City of Albuquerque Stormwater Construction Site Inspection Report

ESC File No.	C17E119	Project Name:	Horizon Village		
NPDES Id. No.	NMR10023E/NMR10023F	Location:	8814 Horizon Blvd.		
1/20/2022	Owner			Contractor	
Operator	Stillbrooke Homes				
Contact name & title	Chris Kelsey				
e-mail	ckelsey@stillbrooke.com				
Contact Phone #	858-1800				
COA Inspector	Doug Hughes		Start/End Time:	10:30 AM	
Construction Phase:	idle				
Type of Inspection:		Storm Event	Past Storm Event >0.25"	311/Complaint	Follow Up
Weather at time of inspection?		clear		Temperature: ~	40
Estimated date of last storm 0.25" or greater		1/1/2022

EROSION AND SEDIMENT CONTROL PLAN

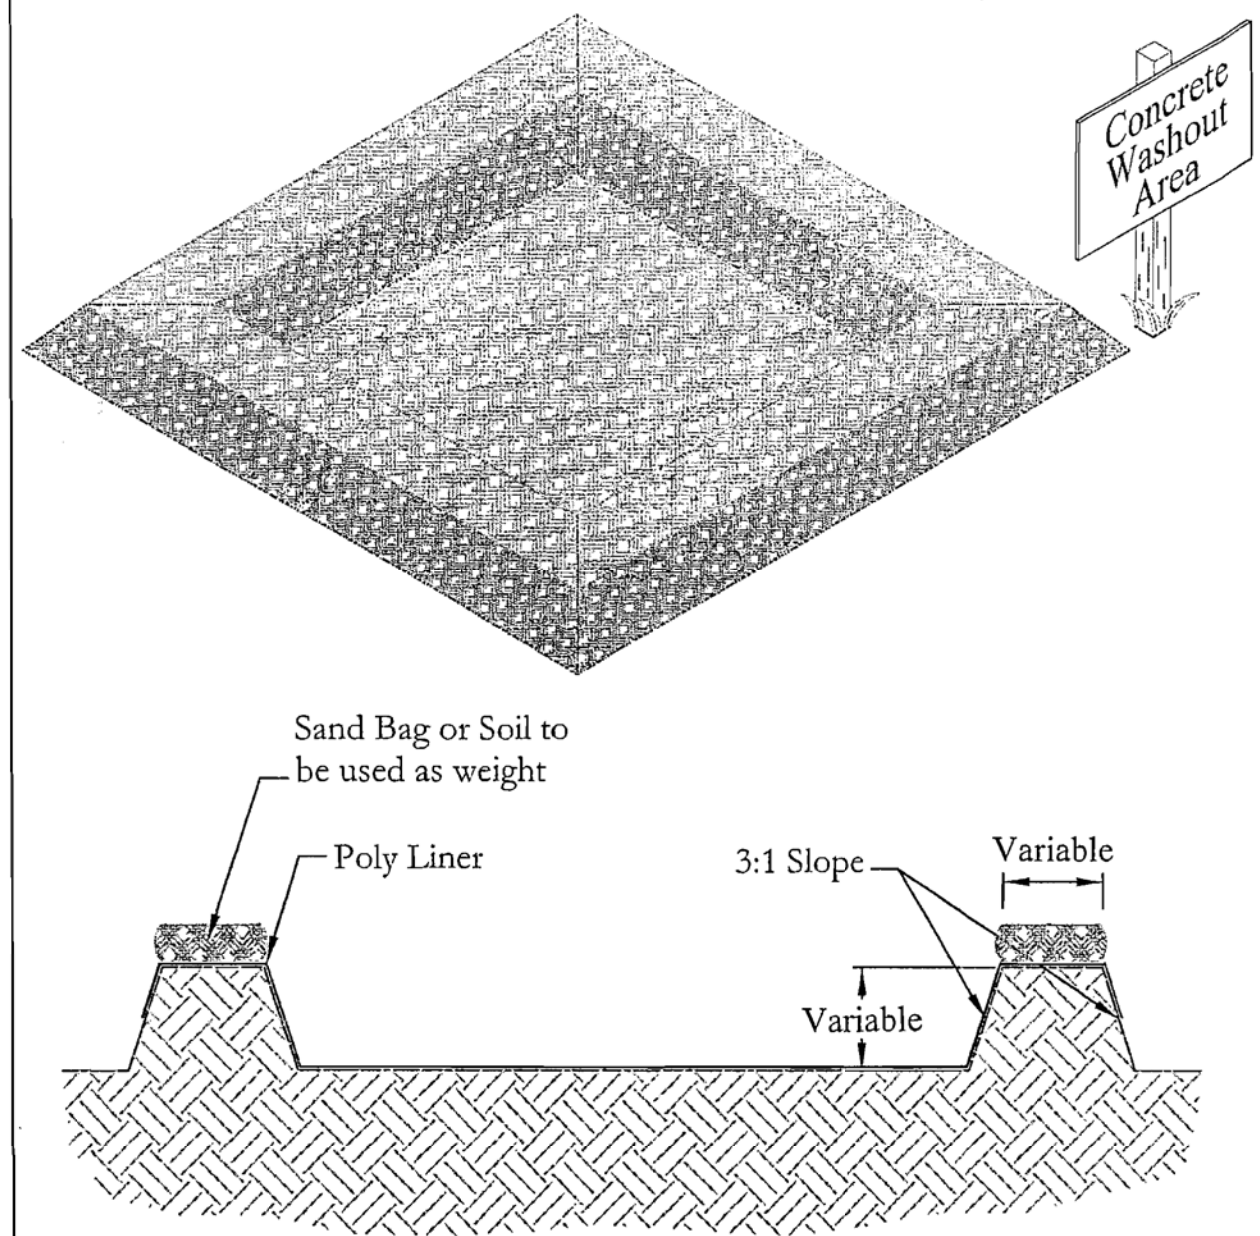
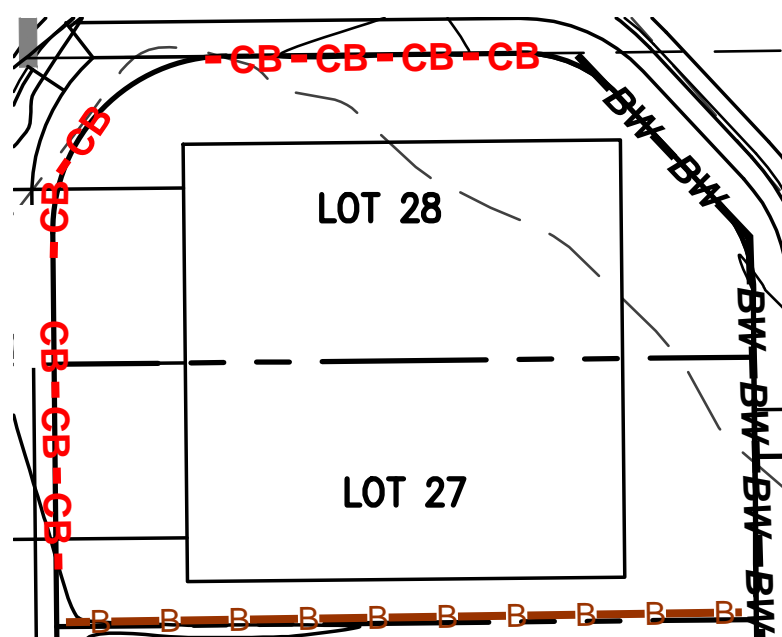
Item Number	Deficiency/ Corrective Action				
1	Washout on the ground. Pick up and remove with waste. Provide lined containers for convenient washout.				
2	Minor sediment in the street. Sweep and remove sediment in the street.				
3	SWPPP was not available onsite. The link provided by Inspections Plus doesn't meet EPA criteria (see attached policy). Viewing on a phone onsite isn't the same as paper, too slow and too small. Provide a computer with large monitor and internet connection or digital files already downloaded on the computer so no lag. The SWPPP wasn't up-to-date, the operator's signatures were missing from all documents in the digital SWPPP, and current conditions weren't marked on the map. Up-date the SWPPP and make it available onsite "same as paper".				
4	Construction and domestic waste isn't in containers that can be covered during non-working hours. Pick up loose waste and place in containers w/ lids.

Notes:	
Only 4 houses vertical, the rest is inactive. Two washout spot on vacant lots and no lined containers anywhere. The posting sign says to contact inspections plus for SWPPP info. They provided a link to unsigned SWPPP and reports.
